Hale Sand, PPR-19-014 (Revised)

Please accept the following comments from El Paso County Public Health regarding the sand mining expansion project referenced above:

SHEET  
**C1.1**

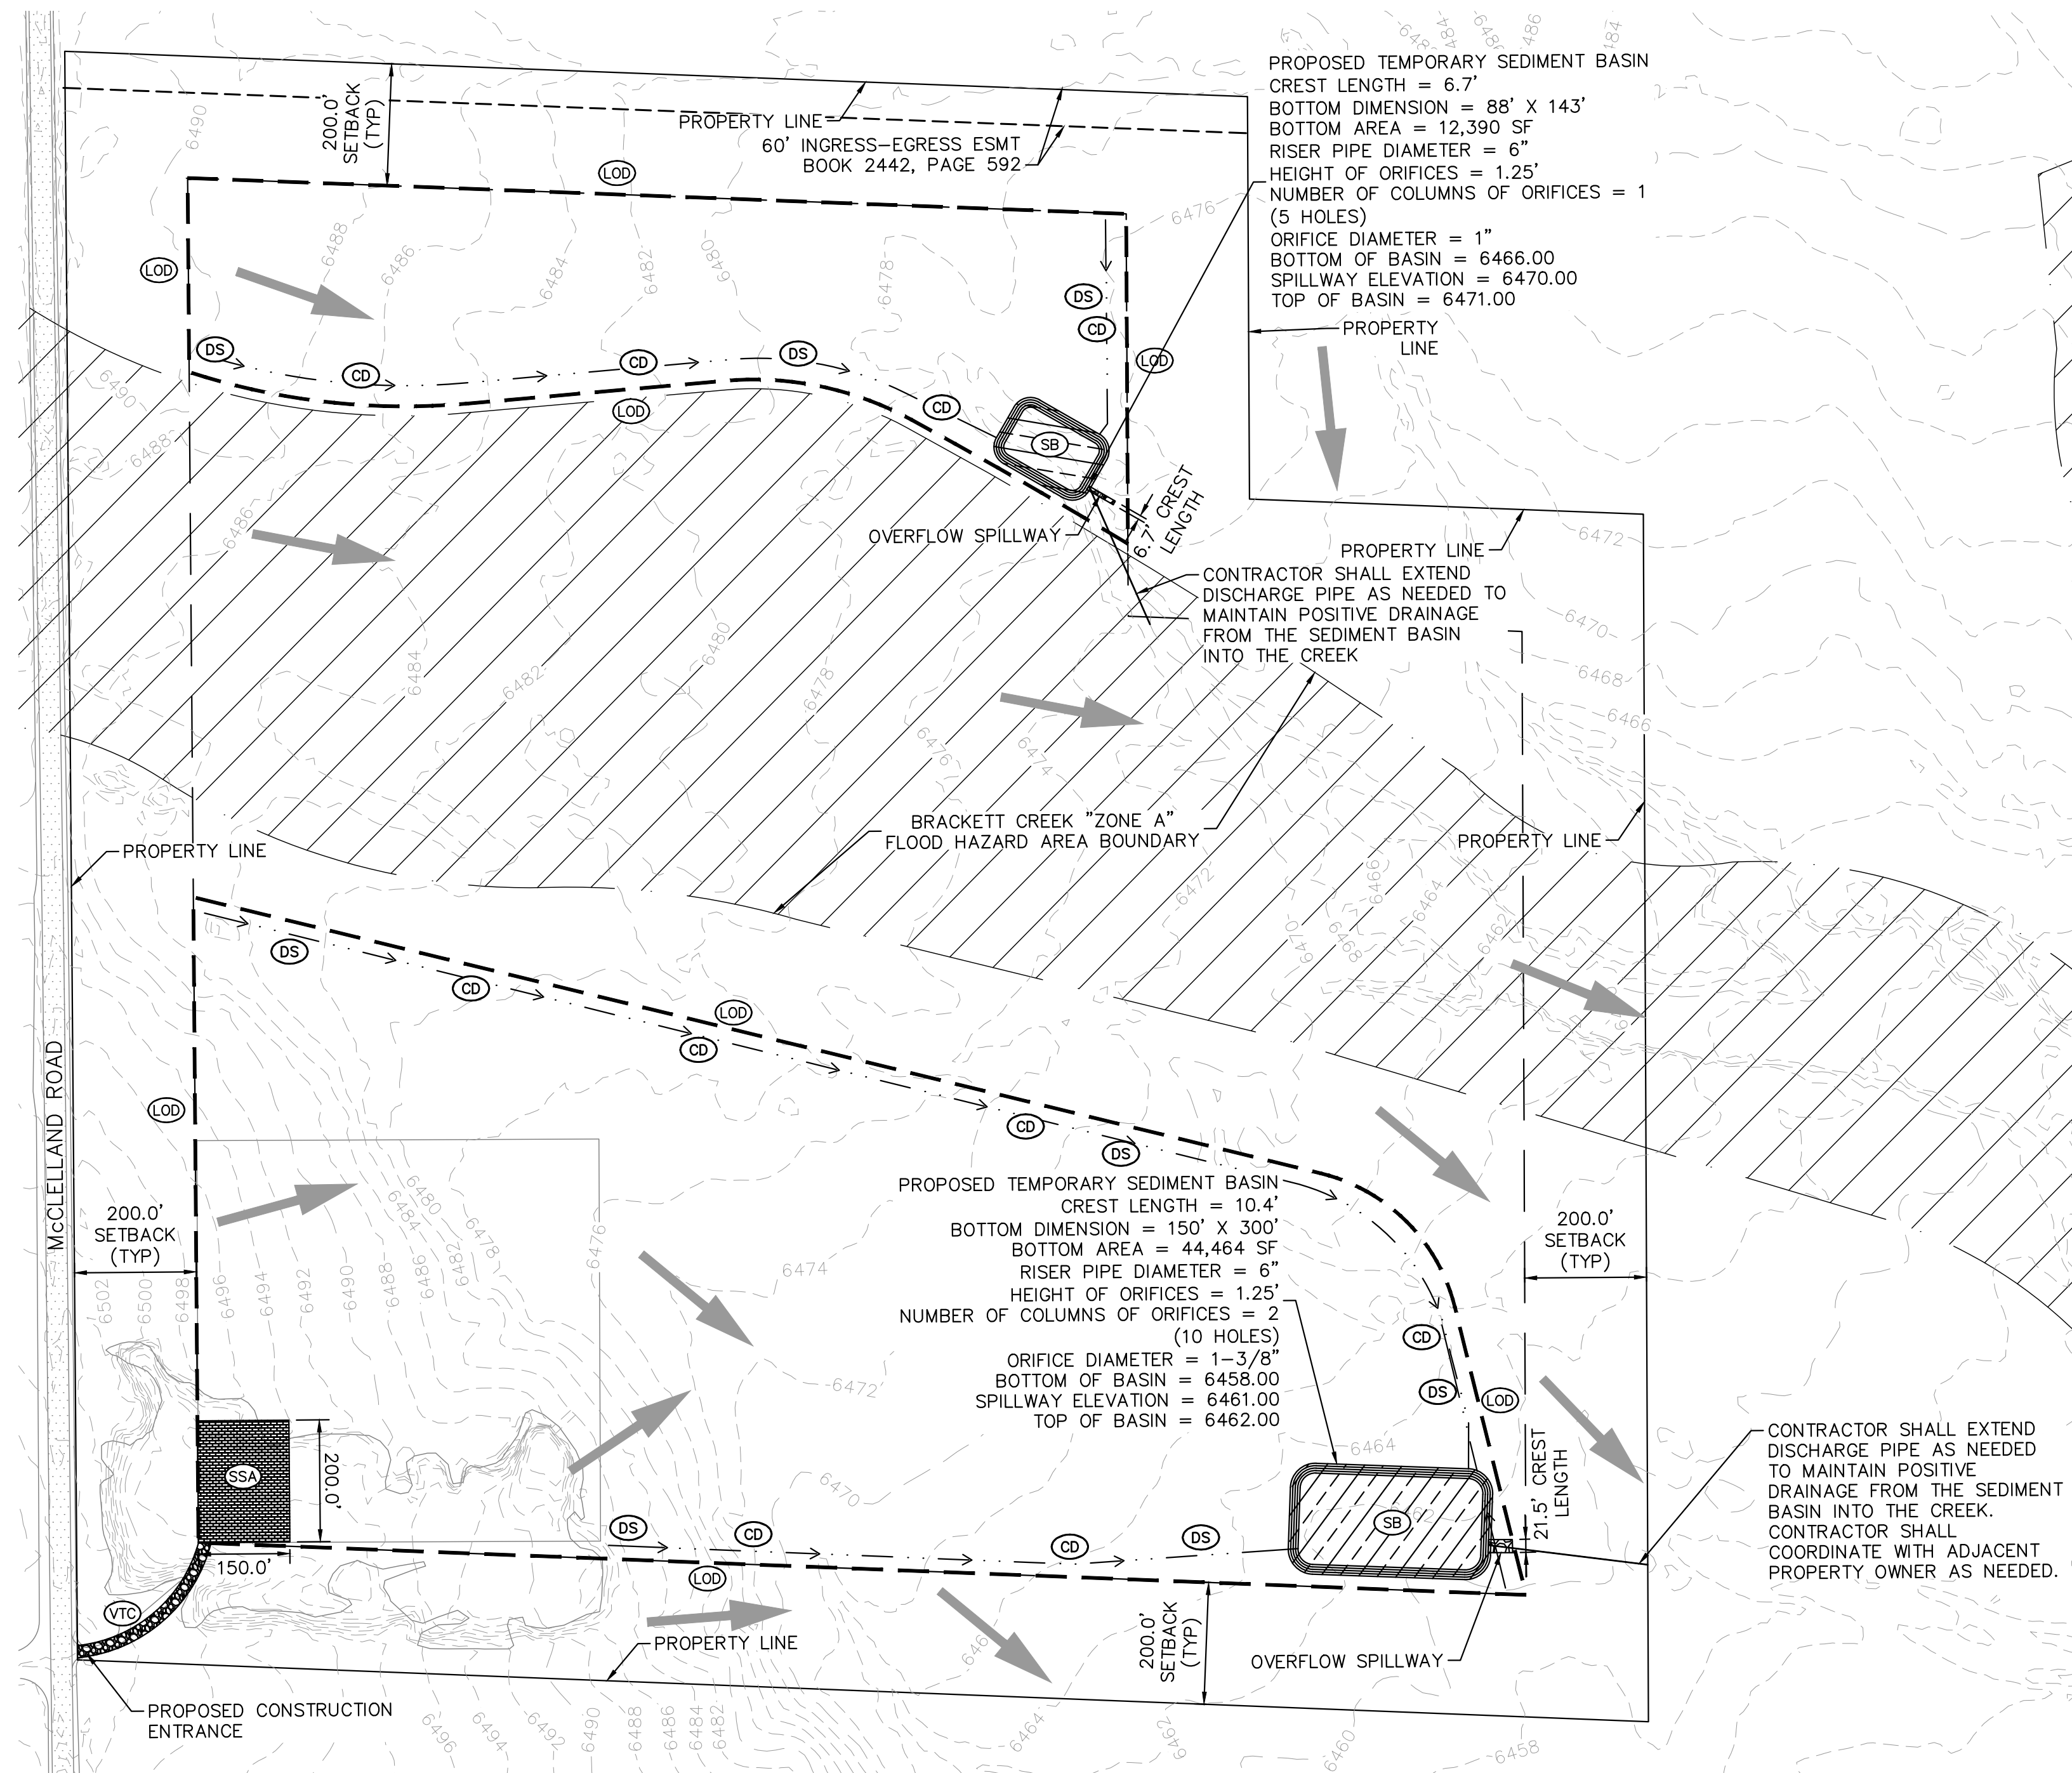
- The proposed water quality detention basin that will capture diverted flows and release storm water at historical rates into Brackett Creek must be designed to completely drain to help minimize mosquito breeding habitat and the potential for West Nile Virus.
